**Re. Narrabri Underground Mine Stage 3 Extension Project (SSD-10269)**

I refer to your request of 29 October 2020 for advice regarding the Narrabri Underground Mine Stage 3 Extension. The Resources Regulator has reviewed the request.

WHITEHAVEN COAL
NARRABRI STAGE 3 PROJECT
Conceptual Final Landform

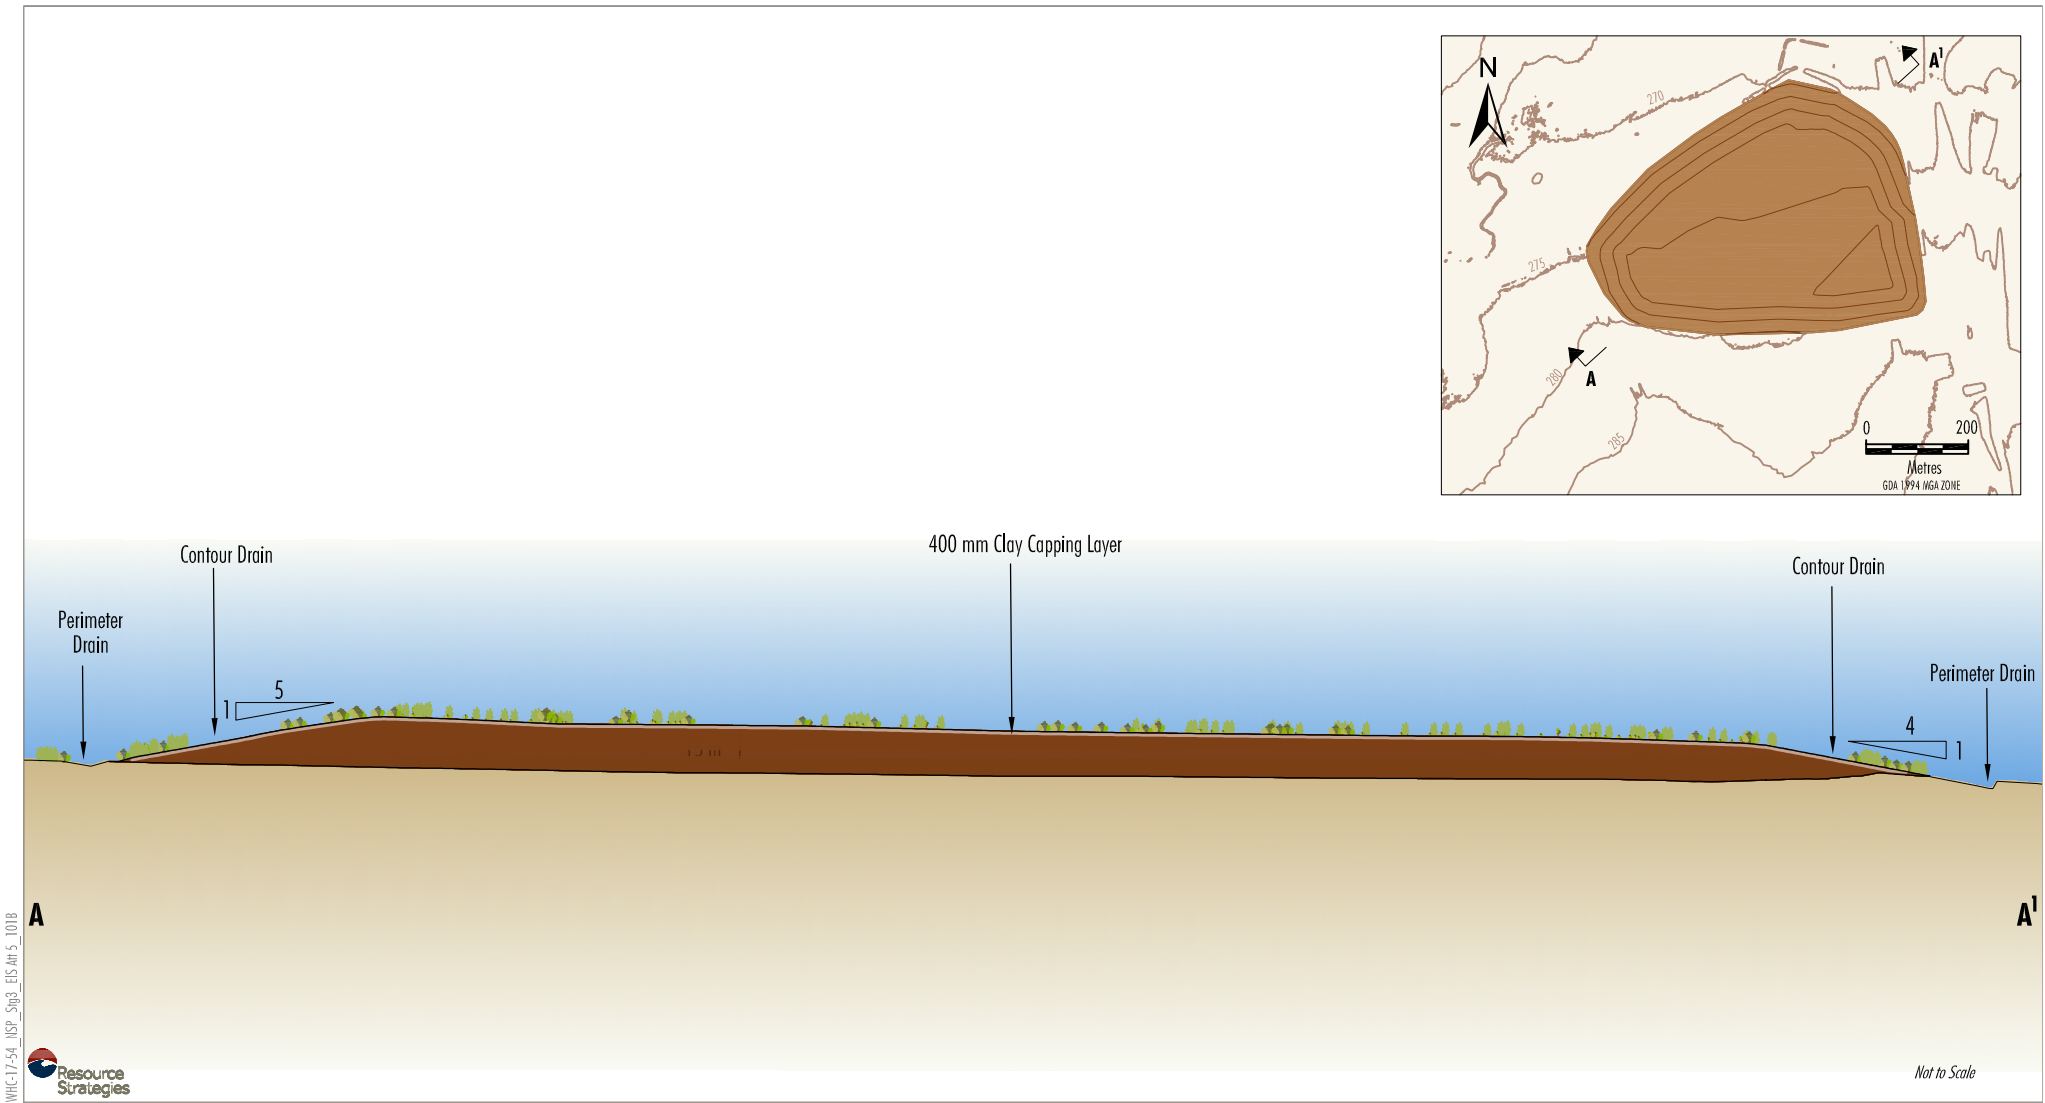
Additional information is required to assess the suitability of geomorphic design principles for the final landform of the Reject Emplacement Area (REA).

As outlined in the letter from the Resources Regulator to DPIE dated 12 April 2019 regarding its Secretary Environmental Assessment Requirements for the Narrabri Underground Mine Stage 3 Extension Project (in Appendix 1 of the Stage 3 EIS), the Regulator specified a requirement to evaluate geomorphological landform design characteristics. It is noted that the EIS does not include an evaluation of this issue, specifically in respect to the existing REA that is proposed to be utilised until the end of the mine life in 2044.

Section A5.2.2 of Attachment 5 (Rehabilitation & Mine Closure) of the Stage 3 EIS describes a conventional final landform design for the REA with limited detail in regard to final surface water drainage. Whilst this section of the EIS references the ATC Williams 2019 review of the REA, which indicates the emplacement design has a very low risk of global batter failure or displacement, further information is required to assess the adequacy of the design for long term stability associated with erosion impacts. This is required to determine its capability to support the final land use outcome of pasture for light grazing. As part of the assessment, an evaluation should be provided as to the feasibility of adopting an alternative geomorphic final landform design.

Further investigation will be required post-approval under the *Mining Act 1992* as part of the requirement to prepare a Rehabilitation Management Plan (currently covered by the Mining Operations Plan). Confirmation of the capping requirements for the REA will be necessary to ensure that the integrity of the cap is capable of sustaining grazing as well as natural tree growth post closure whilst ensuring that the reject material remains encapsulated in the long term.
